FORMAL PLANNING OBJECTION

State Significant Development Application

Reference: **SSD-93020230**

Proposed Development: 40–48 Redan Street, Mosman NSW 2088

40-48 Redan Street, Mosman 40-48 Redan Street Mosman NSW 2088	Section 3 EW South Sections	Rev	Date	Description	By	Chk	Scale	Code	Sheet	Rev	02.5510m
		B	27/2/2026	SSD Submission	Lodgment	IS	1:250 @ A3	TPRS	4002	B

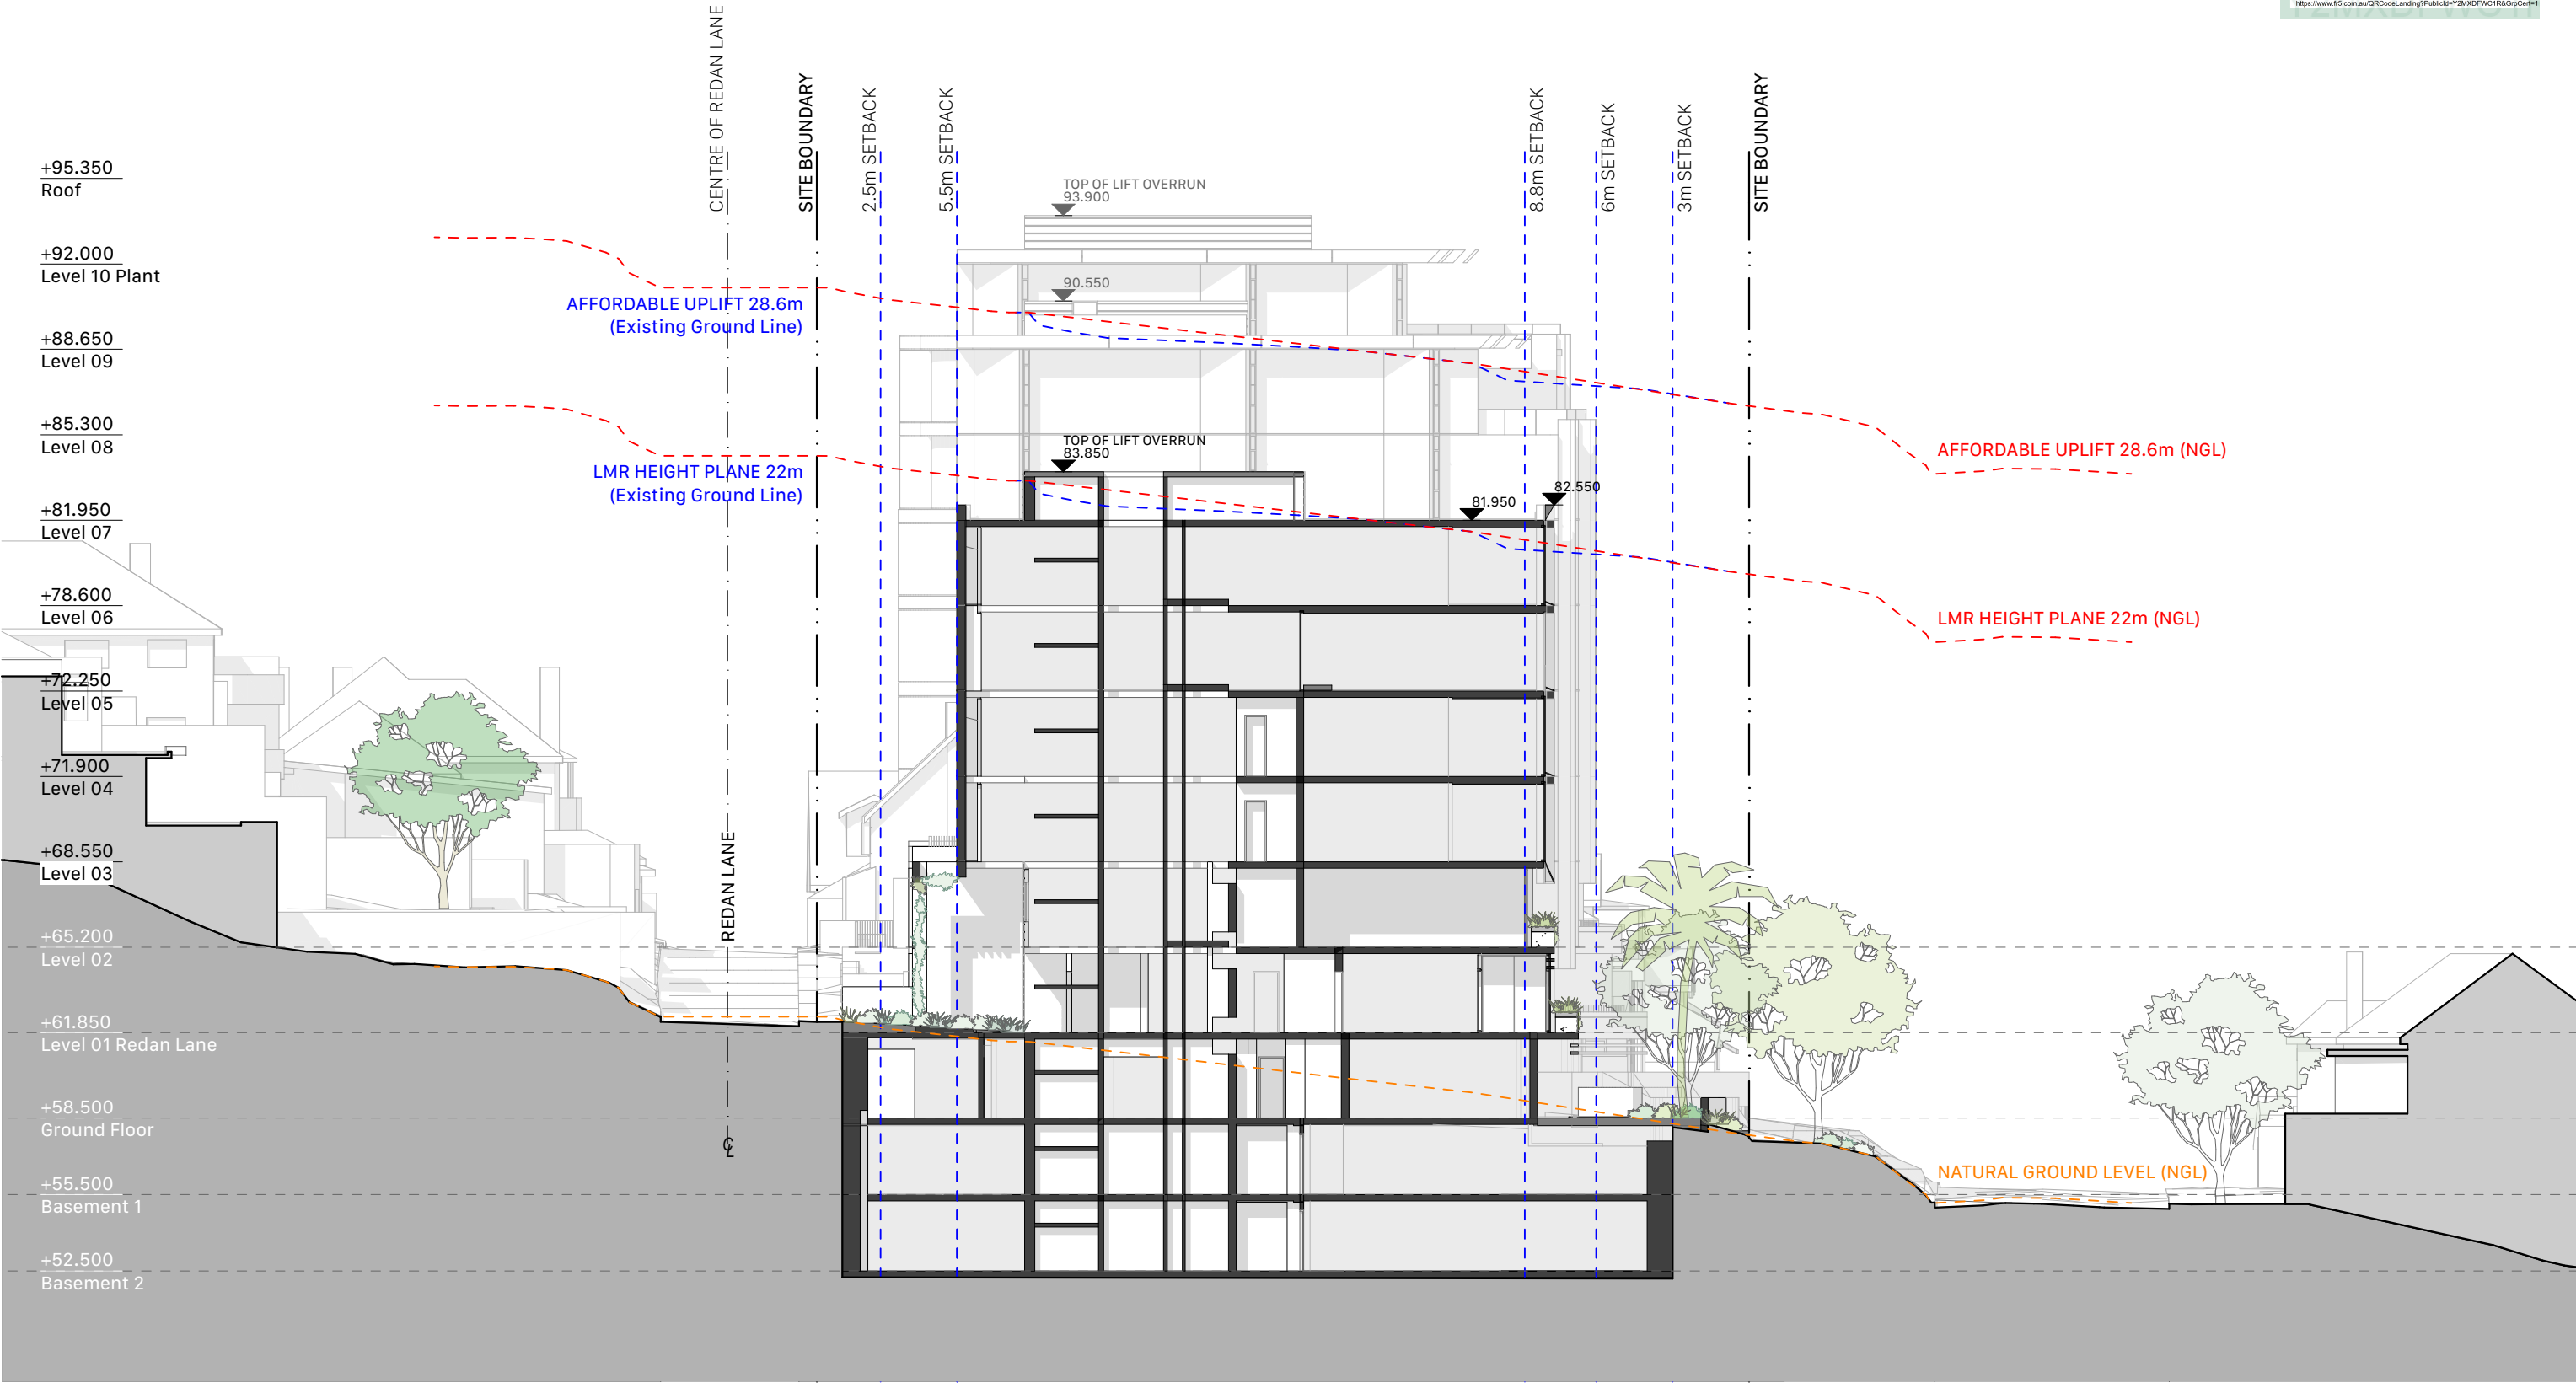
This characterisation is demonstrably false. The architectural drawings in the application - Appendix B of the EIS - show clearly that land falls to the east of the development site. The site is in a mid-slope condition, not on a ridgeline. This is not a matter of interpretation. It is a fact that can be verified by examining the plans the applicant has lodged.

Because the topography misrepresentation underlies both the Visual Impact Assessment and the shadow and privacy analysis in the EIS, it contaminates the reliability of those assessments. The Department should require the applicant to resubmit both assessments based on an accurate representation of the site's topographic position before any further assessment of the application proceeds.
